**RE: APD Community Safety Department Facility  
Lot 20-A, Block 9. Virginia Place Add'n  
1138 San Mateo Blvd. SE  
Grading Plan  
Hydrology File: L18D054A**

Based upon the information provided in your submittal received 10/18/2022, the Grading plan is **not approved** for Building Permit. The following comments need to be addressed for the approval of the above referenced project.

Design Review Committee	City Engineer Approval	Mo./Day/Yr.	Mo./Day/Yr.
PERMIT DRAWINGS	City Project No. 7881.00	DG Project No. 6600.AS32	Zone Map No. L-17-Z
		DWG.	CD-1
			Sheet

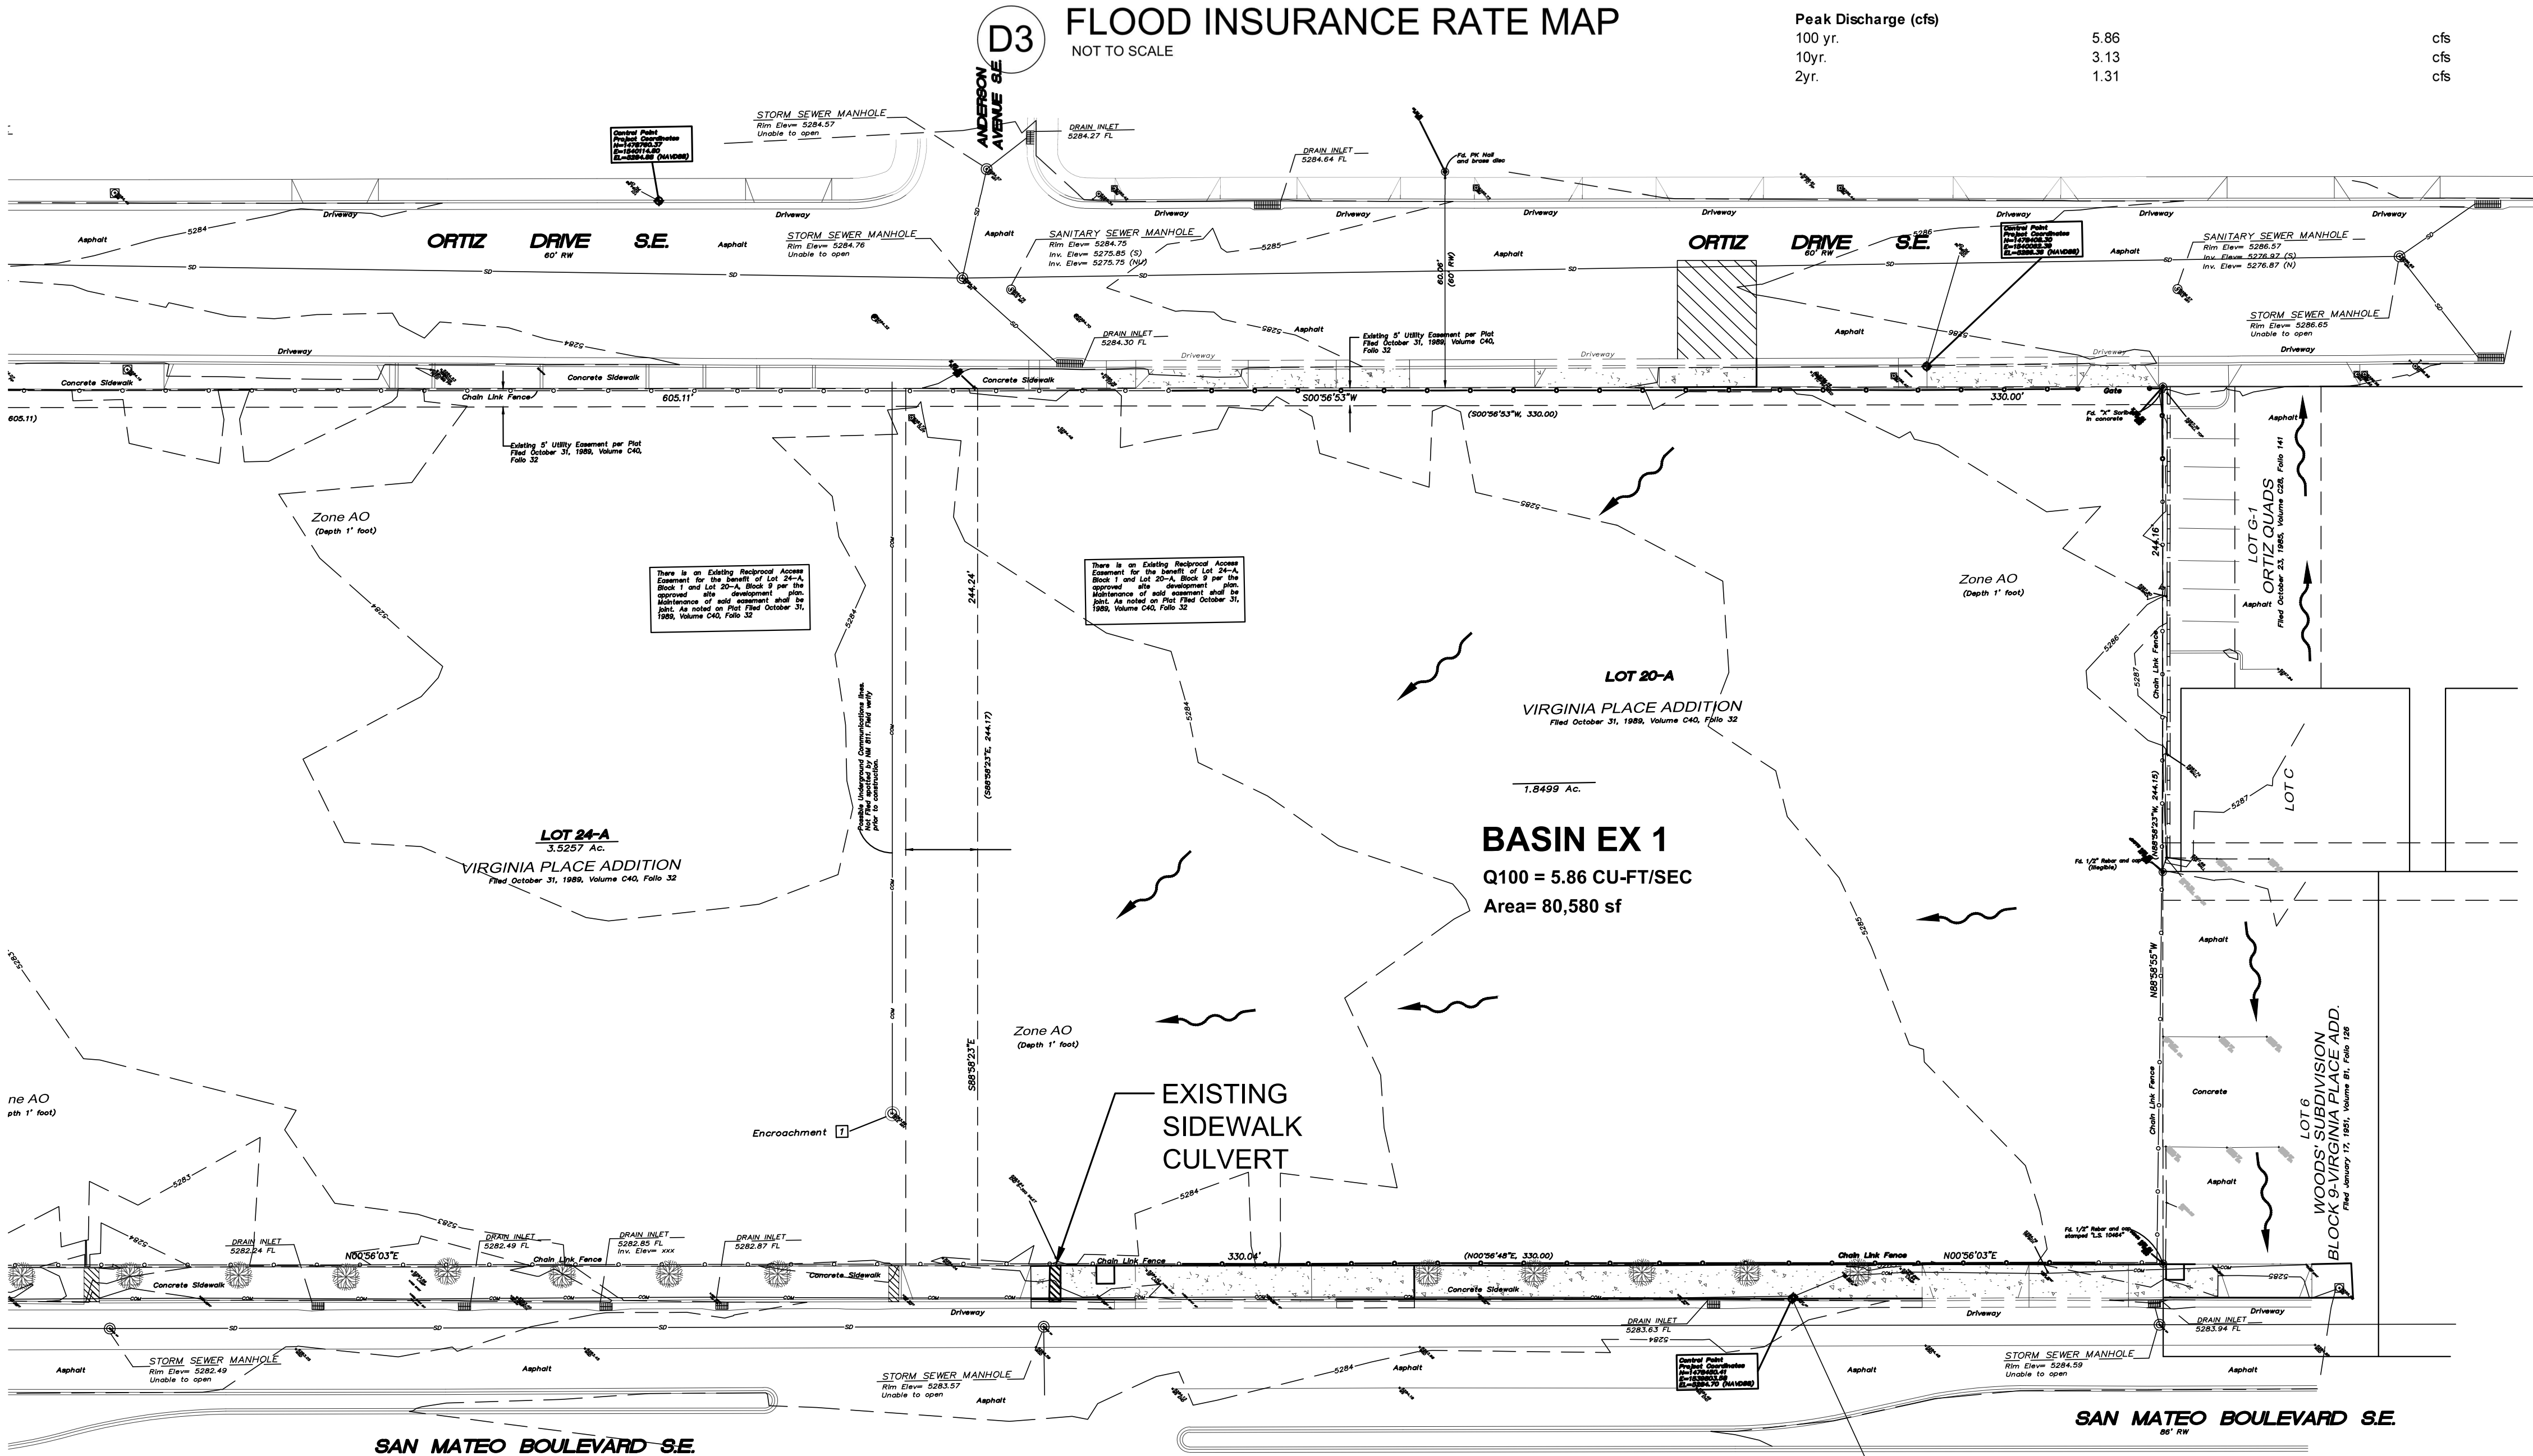
1. Please insert a vicinity map on sheet C-201, CD-1. Add sheet numbers on the plan.
2. Please ensure the plan has engineer's stamp dated and signed on each sheet.

3. This site is in FEMA designated floodplain zone AO (Depth 1 ft), proposed detention ponds shall retain the displaced water volumes, not just the water quality volumes. Or a letter of map revision (LOMR) shall be filed to FEMA for review and approval if the nearby SD systems have enough downstream capacity.

4. There are proposed detention ponds. Please provide sections for each detention pond. This should show the detention volume, water surface elevation, property/ROW lines, existing and proposed grades.

5. Submit Flood Plain Permit to PLNDRS for review and approval.
6. Is the future addition included in the drainage calculations?
7. Mark the concrete channels and riprap channels on sheet C-201, CD-2.

8. Correct the pond A available volume to 1,061 CU-FT instead of 1,06 CU-FT in Pond A build note on sheet C-201, CD-2.
9. It seems like the total storage volume of 3,193 CF in the "Pond routing and volumes" table missed pond A volume in calculations. Please verify.
